Oakdale West Industrial Estate Stage 3 (SSD 9794683) – Amended Development Application

This Amended Development Application (DA) Request has been prepared by *Keylan Consulting Pty Ltd* (Keylan) on behalf of *Goodman Property Services (Aust.) Pty Ltd* (the Applicant). The request is submitted for the Oakdale West Industrial Estate (OWE) Stage 3 State Significant Development (SSD) application (SSD 9794683), which was lodged on 10 February 2021.

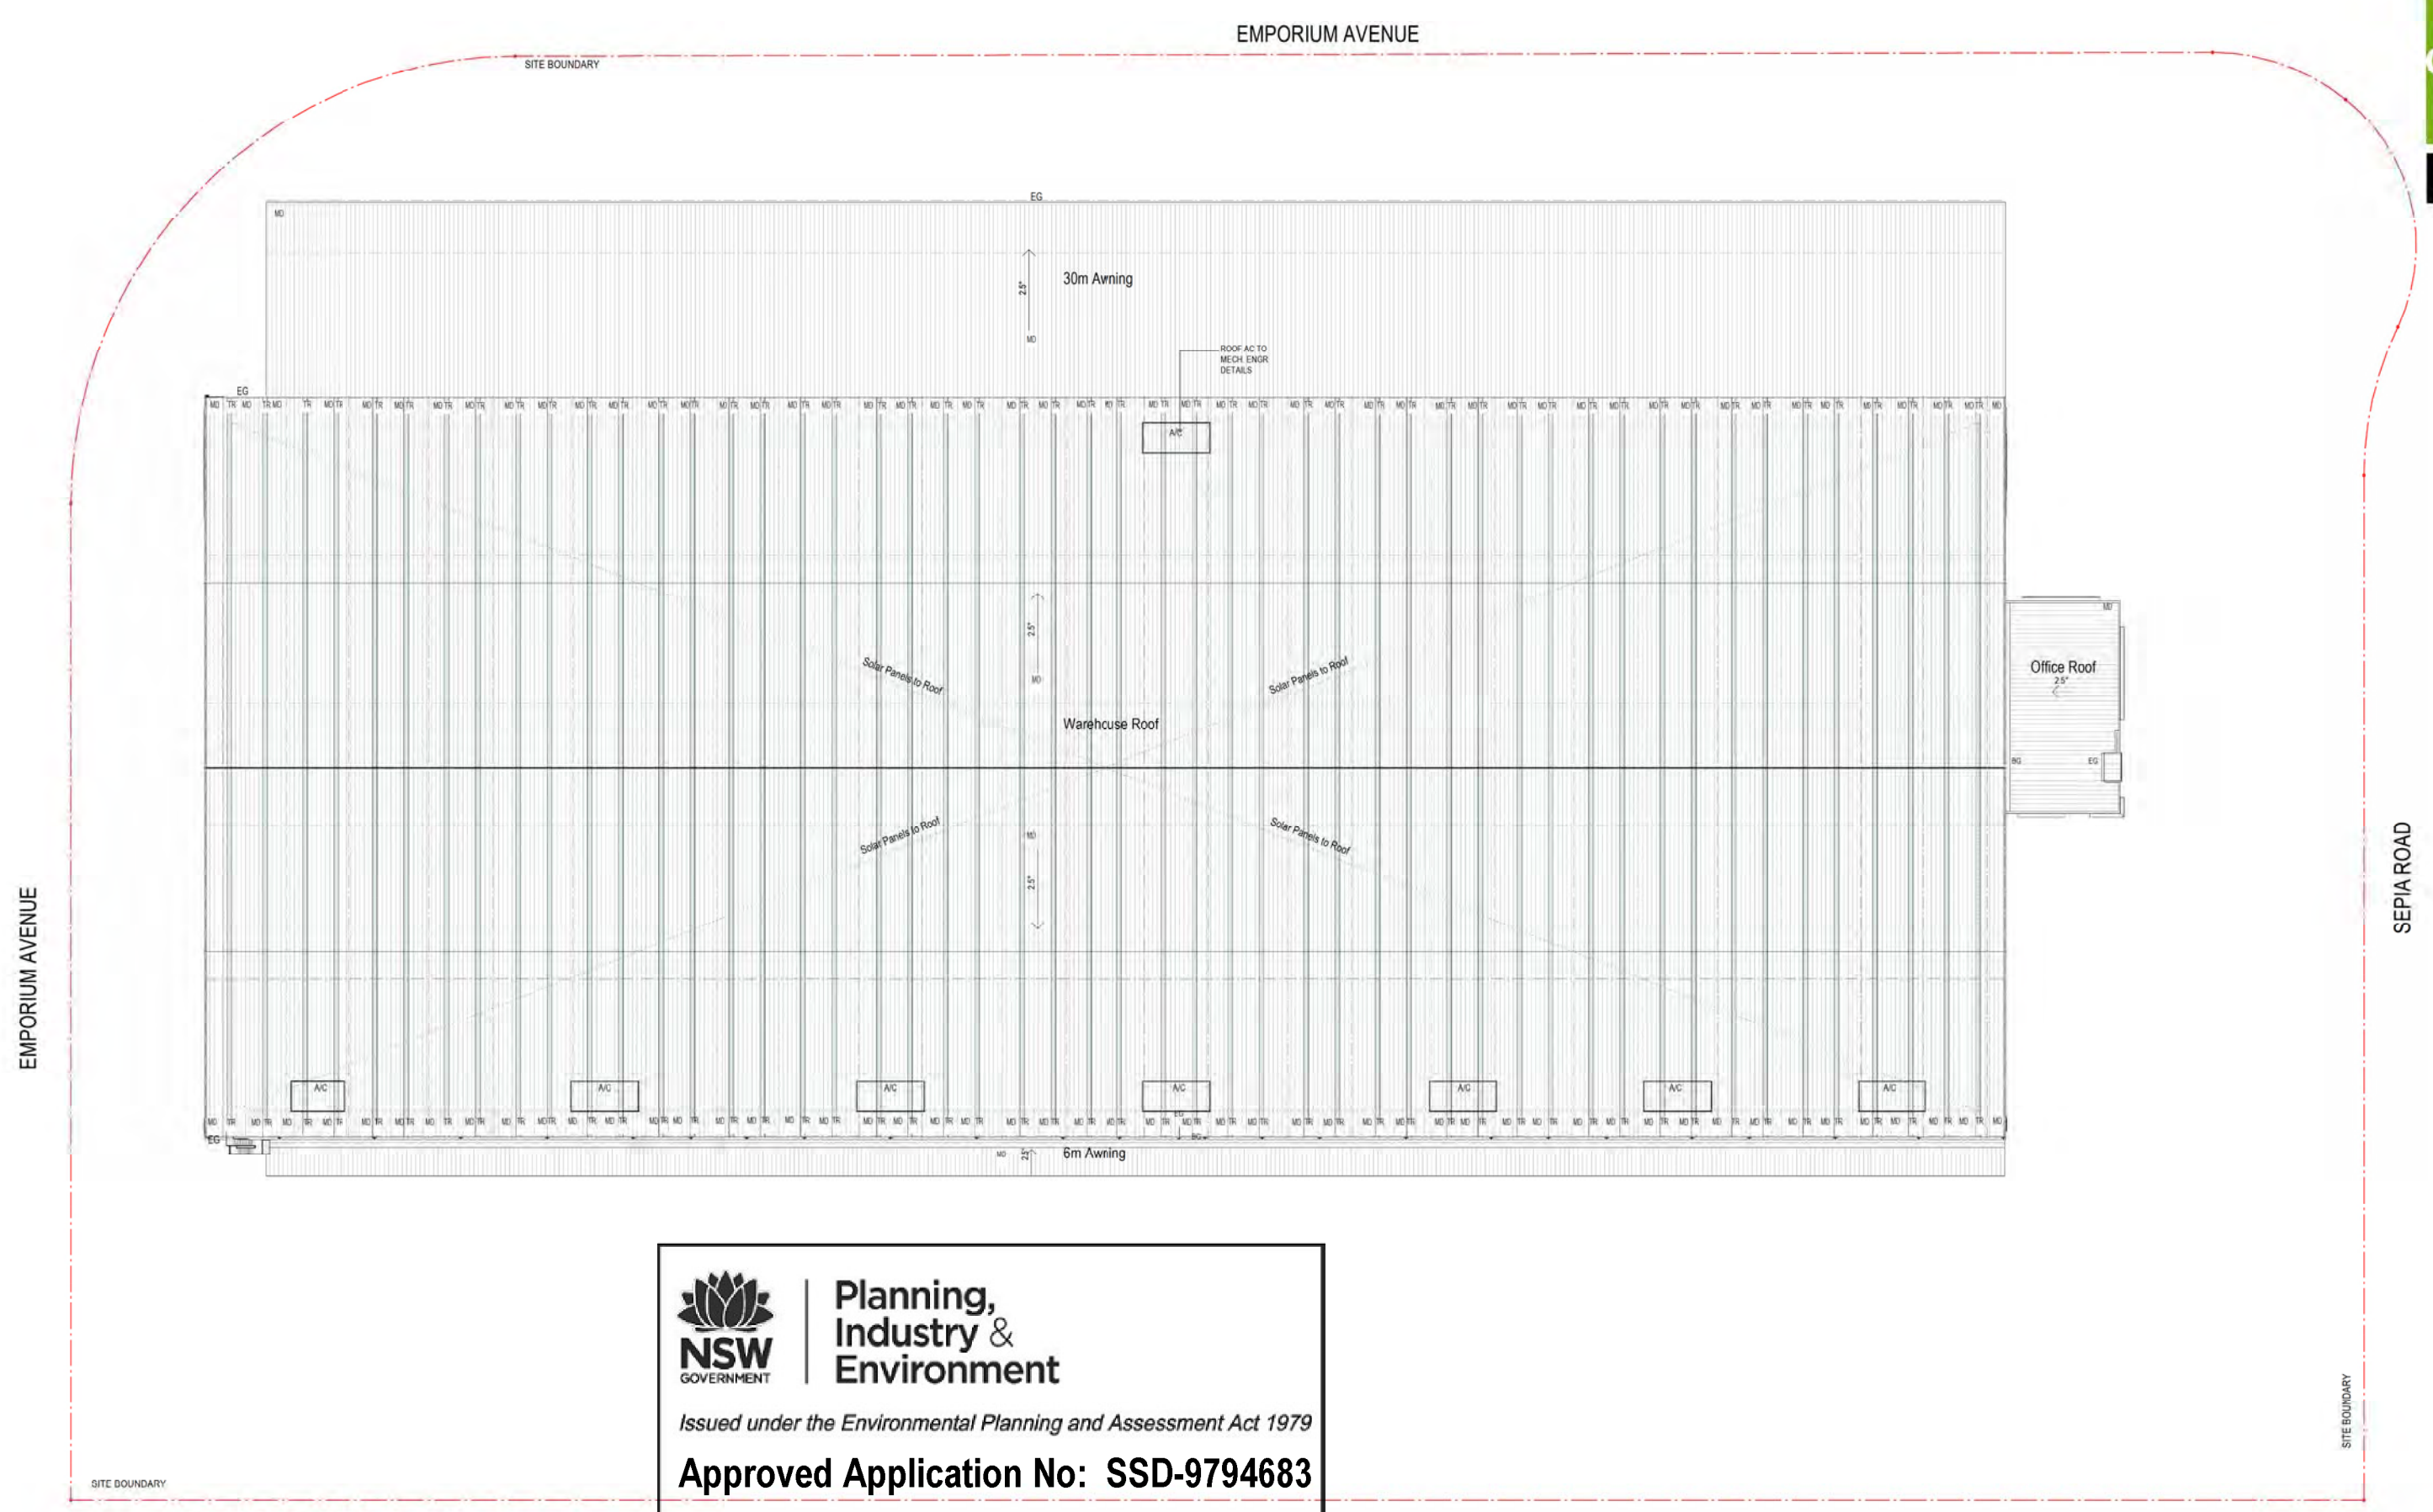
The tenant for Building 2A intends to use the warehouse for parcel processing and distribution. The key proposed amendments to Building 2A include:

- 1.2 m reduction in ridge height (from 14.9 m to 13.7 m)
- Changed access for car and truck entry/exit points
- Peak traffic generation occurring outside the estate network peak periods of 7 am to 8 am and 5 pm to 6 pm, changing to 5 am to 7 am and 9 pm to 11 pm

- 47 additional car parking spaces (from 208 to 255 spaces) and repositioning of the carpark to the eastern side of the site
- Use of temperature control at the southern dock with units placed on the warehouse roof

1 PERSPECTIVE 01

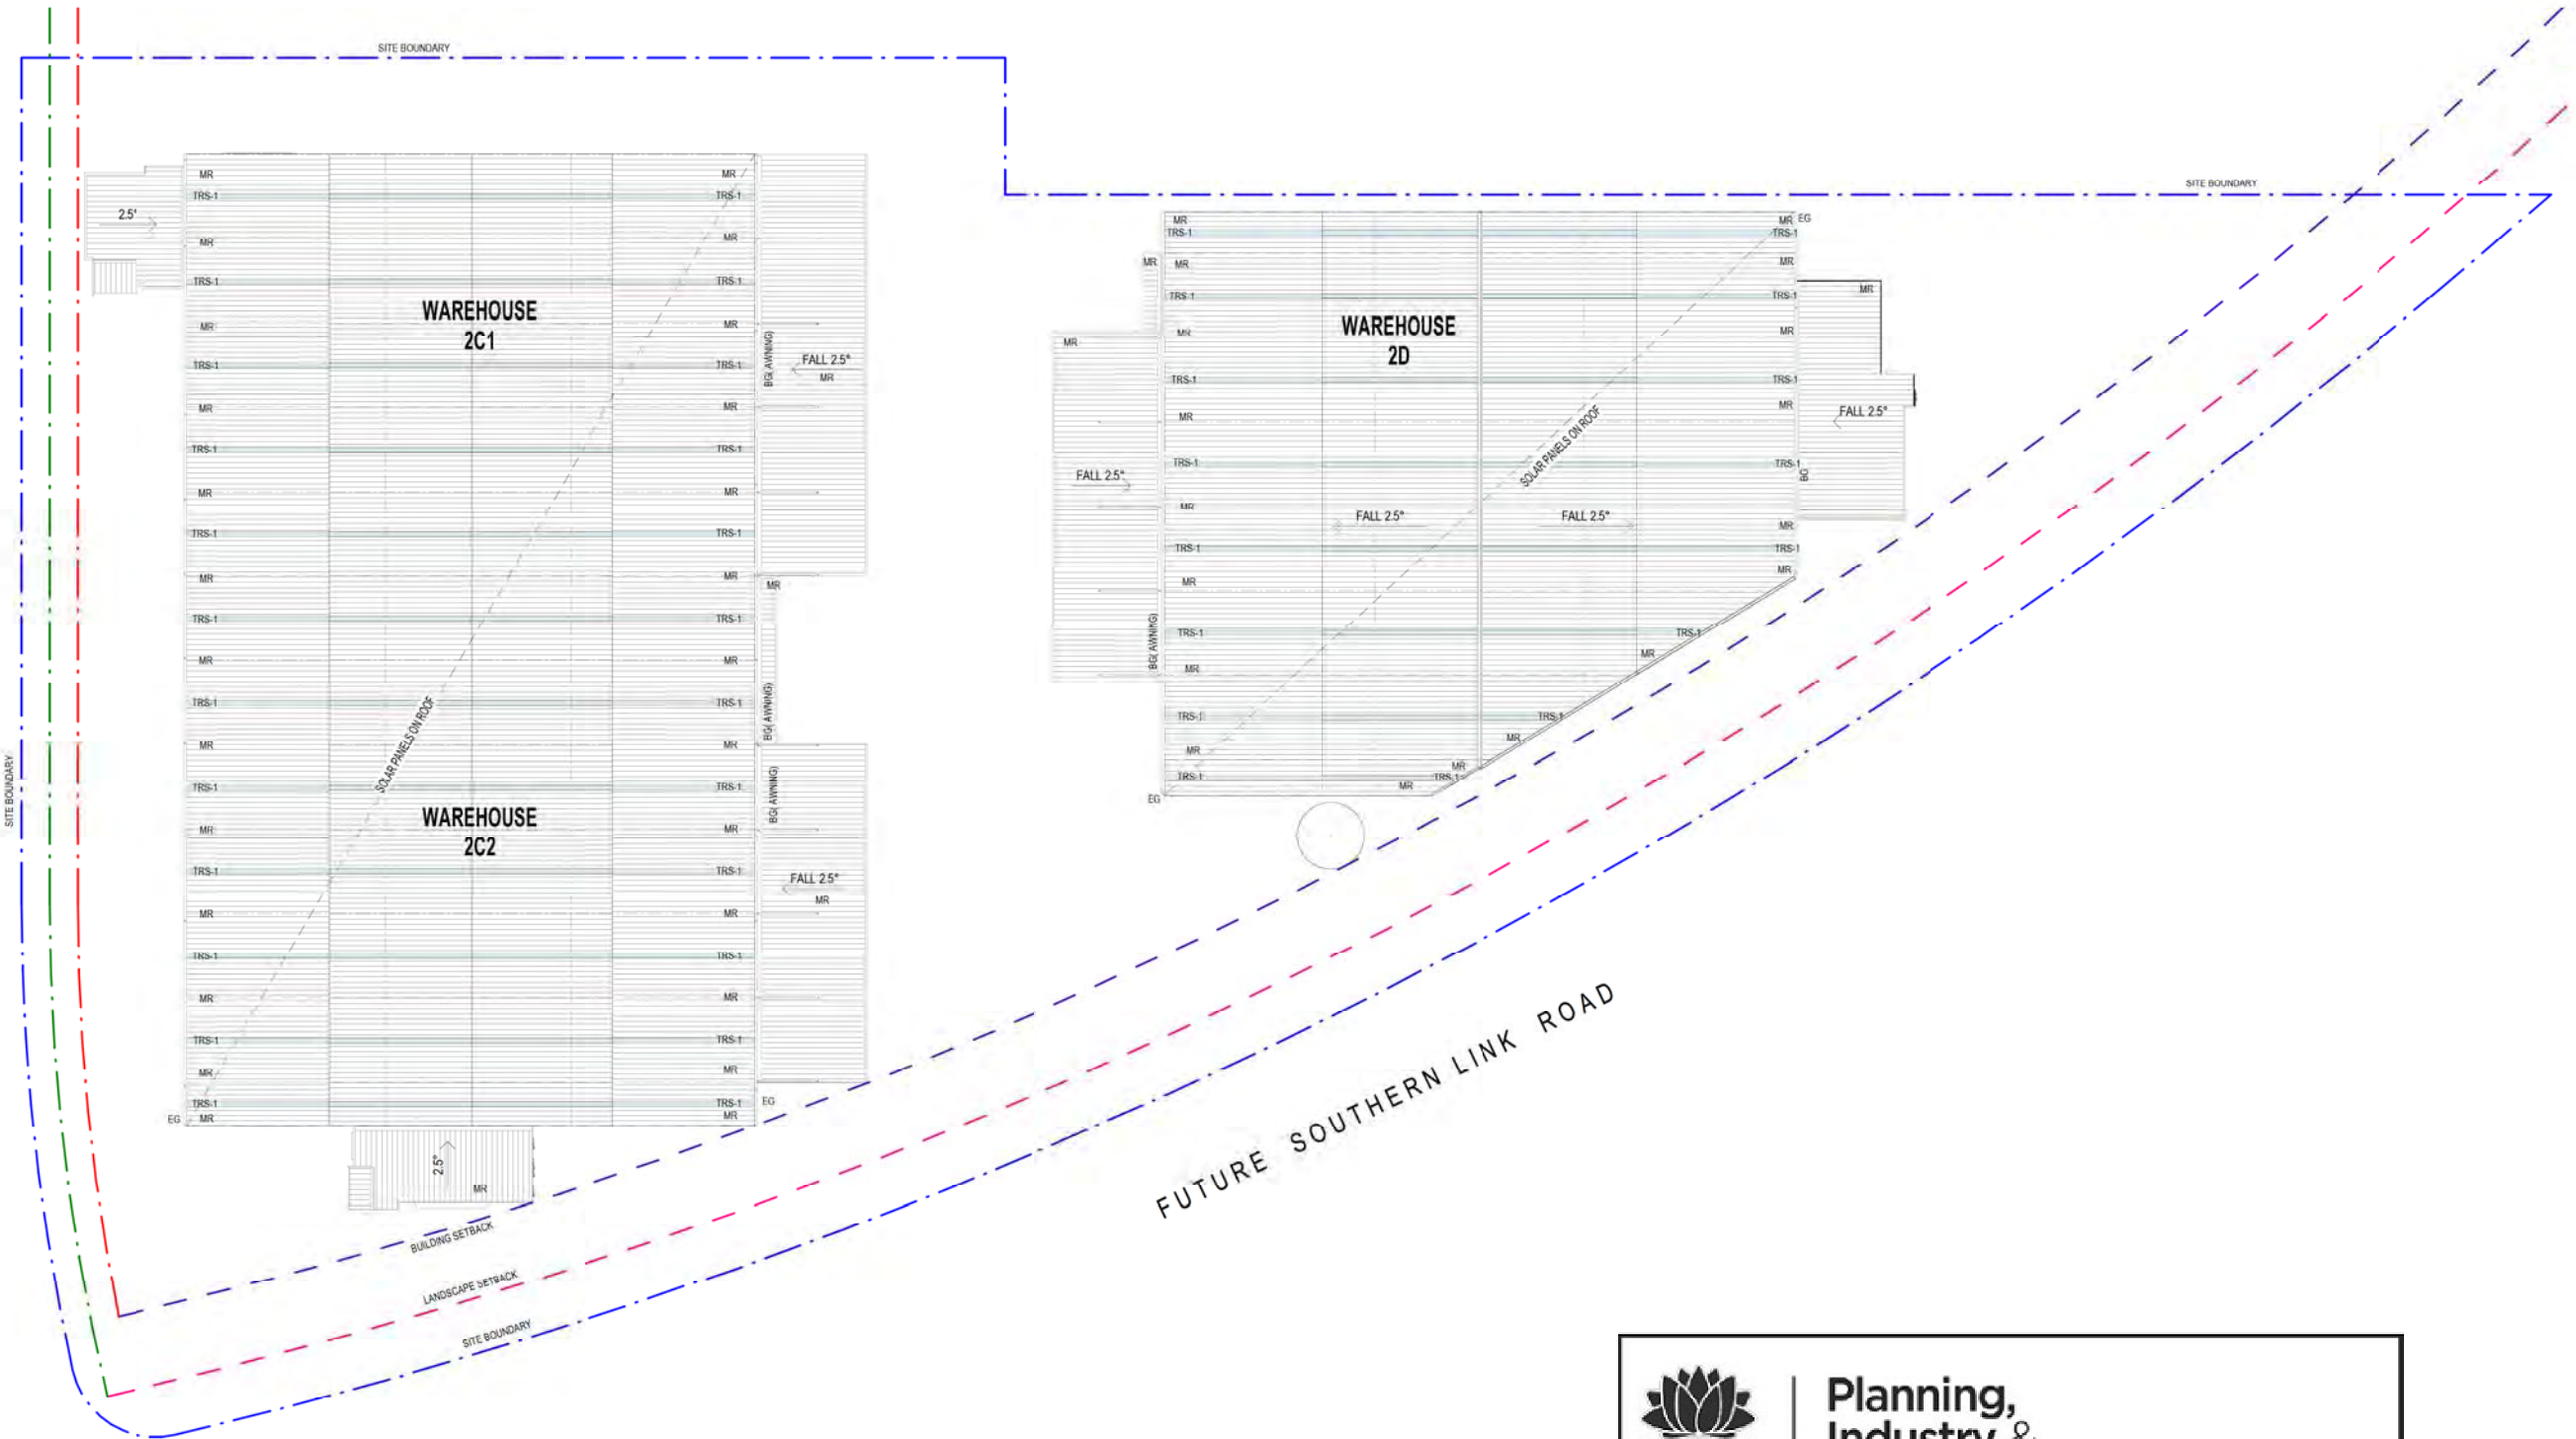
The Department notes that a shared light and heavy vehicle driveway is proposed for access to the Building 2D car park. The Department agrees with Council that this has potential traffic safety impacts along the driveway and within the loading dock area. It is requested that an alternative access arrangement be provided for light vehicles to the car park, noting that landscape setbacks along each boundary must be maintained.

Figure 3 shows the originally proposed site and warehouse plan, with shared access for heavy vehicles and light vehicles accessing the carpark for Building 2D. Figure 4 shows the revised scheme whereby access to Building 2D car parking is provided via the same driveway which accesses parking for Building 2C.

The amended access to car parking for Building 2D reduces any potential for conflicts between truck and car movements. The revised access requires the provision of an access driveway and parking along the southern boundary of the lot. The access driveway does not encroach into any required setbacks, including landscaped.

The proposed amendments include a 2% increased overall site coverage (from 43% to 45%) with 3 additional car parking spaces (from 50 to 61 spaces) at Buildings 2C1 and 2C2. The proposed amendments to Building 2D include:

- an 855 m² (17%) increase in building footprint (from 5,005 m² to 5,860 m²) and corresponding 855 m² (16%) increase in overall GFA/GLA (from 5,380 m² to 6,235 m²)
- one additional car parking space (from 55 to 56 spaces)
